CITY OF ALBUQUERQUE

March, 5 2020

Re: Blue Sky @ 12th Street
311-319 12th Street
Traffic Circulation Layout
Architect's Stamp 02-20-20 (K13-D077)

PROJECT #	1906
DATE	04.22.20
SHEET #	TCL-1

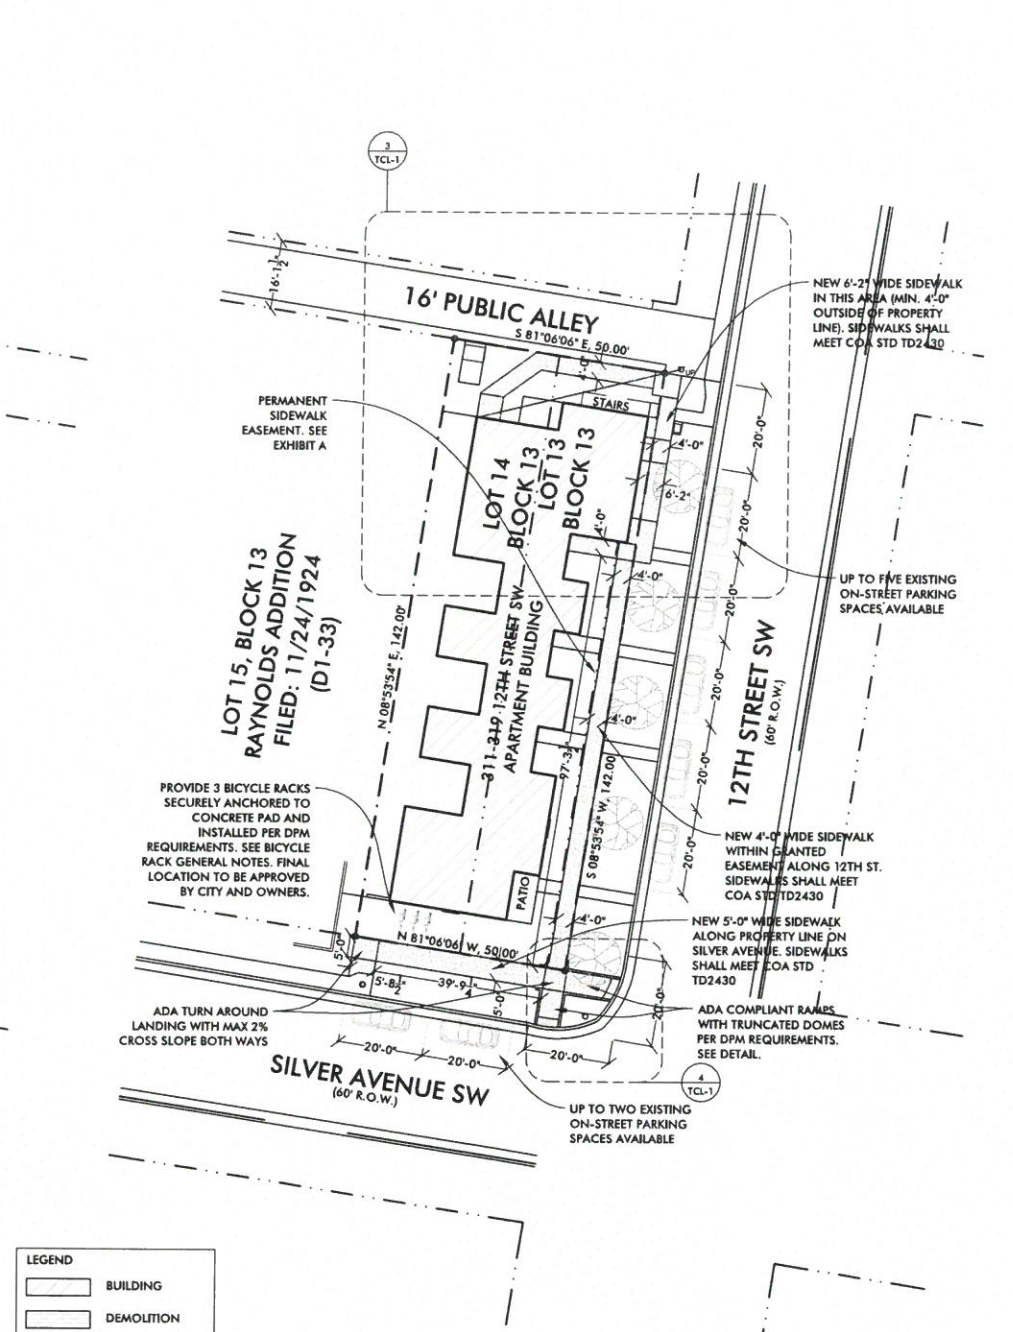
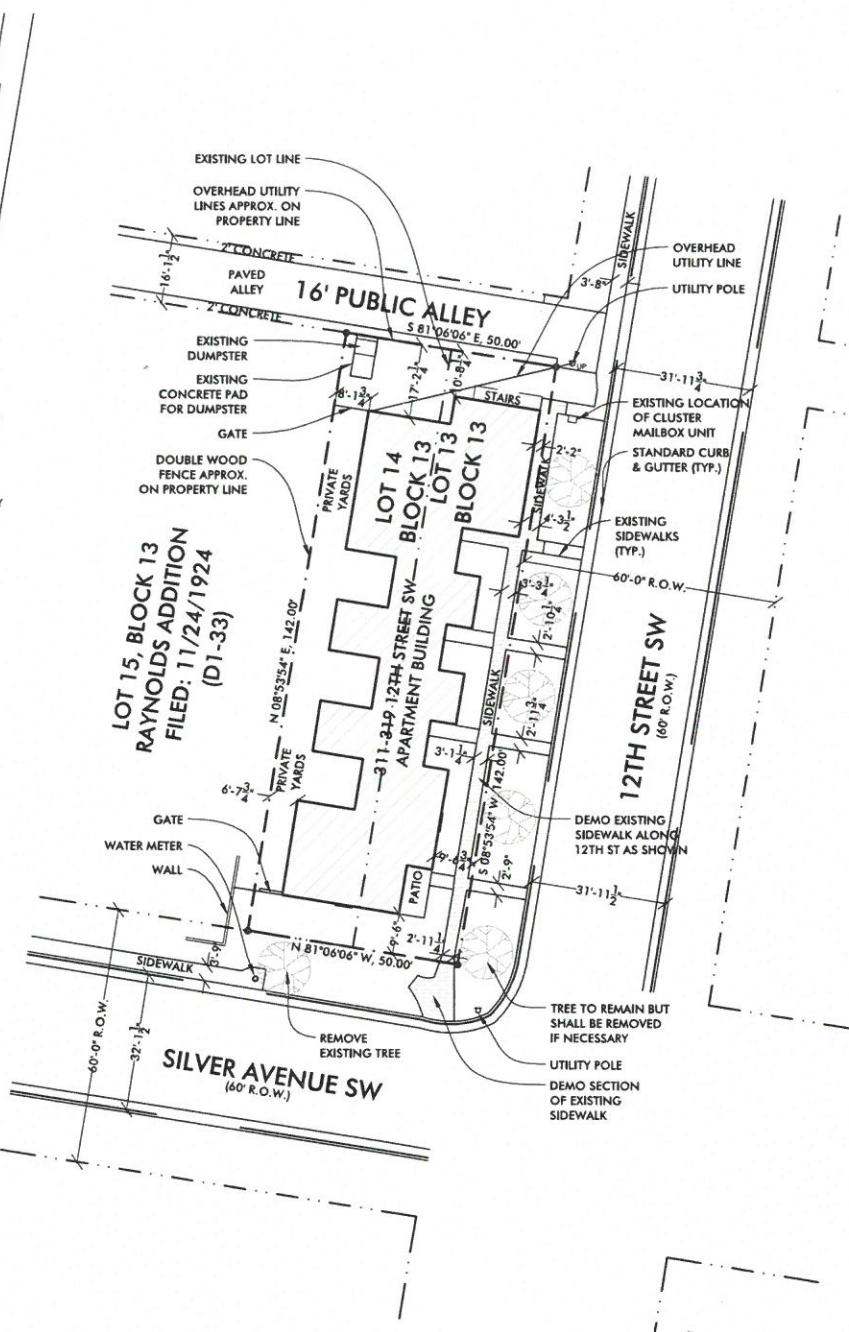
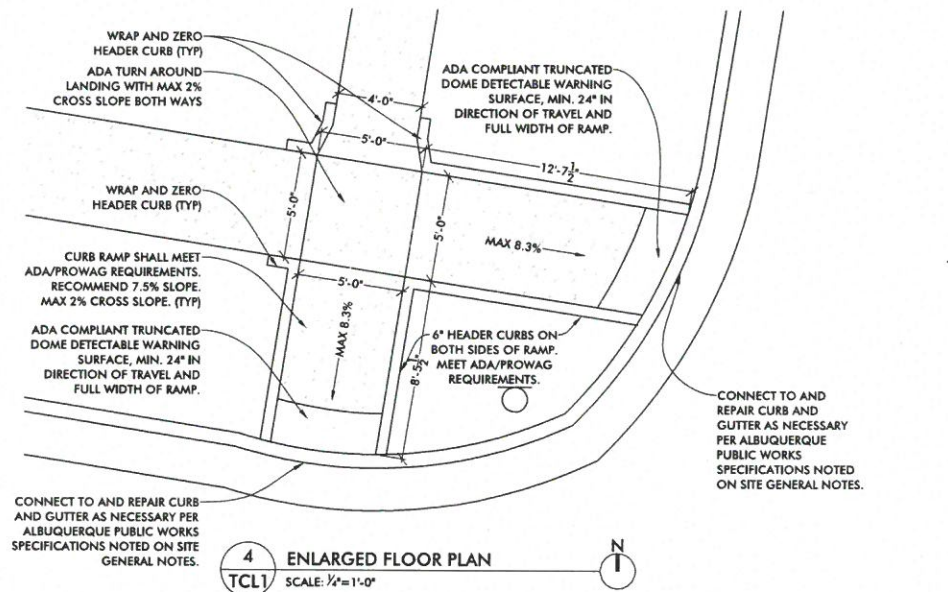
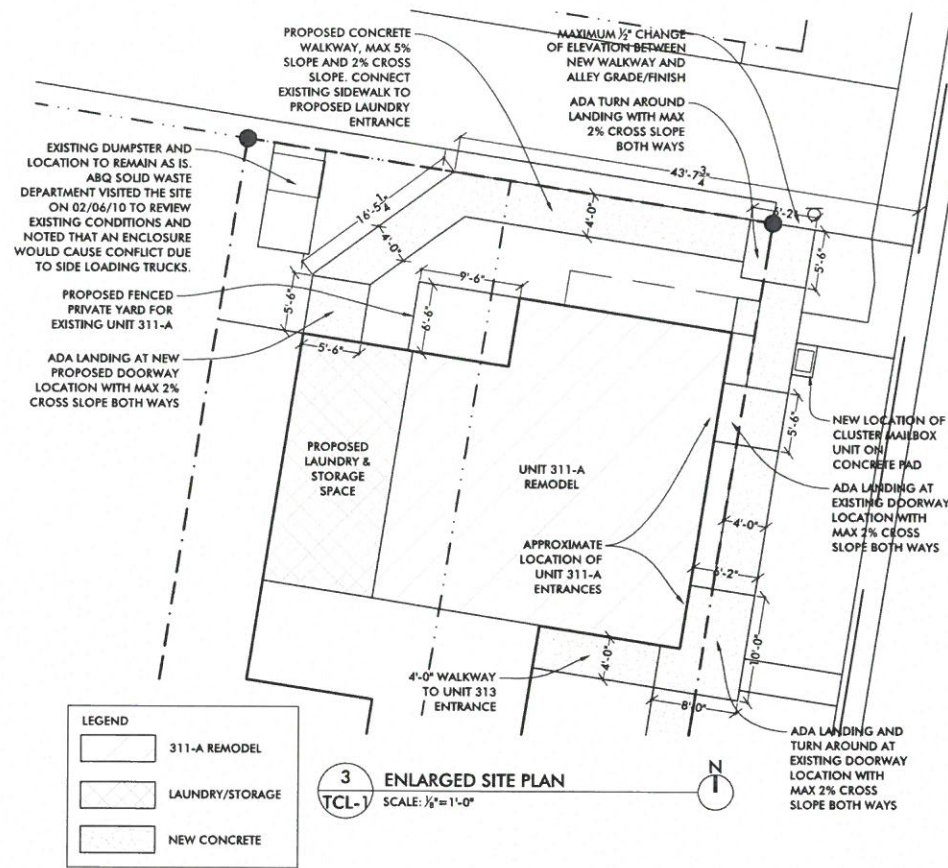
1. Please review and revise plan to provide all information listed on the attached Traffic Circulation Layout checklist.

sidewalk and Standard C & G are shown but not labeled whether they are proposed or existing

what is the status of ADA wheel ramp at the corner of Silver Ave & 12th St.?
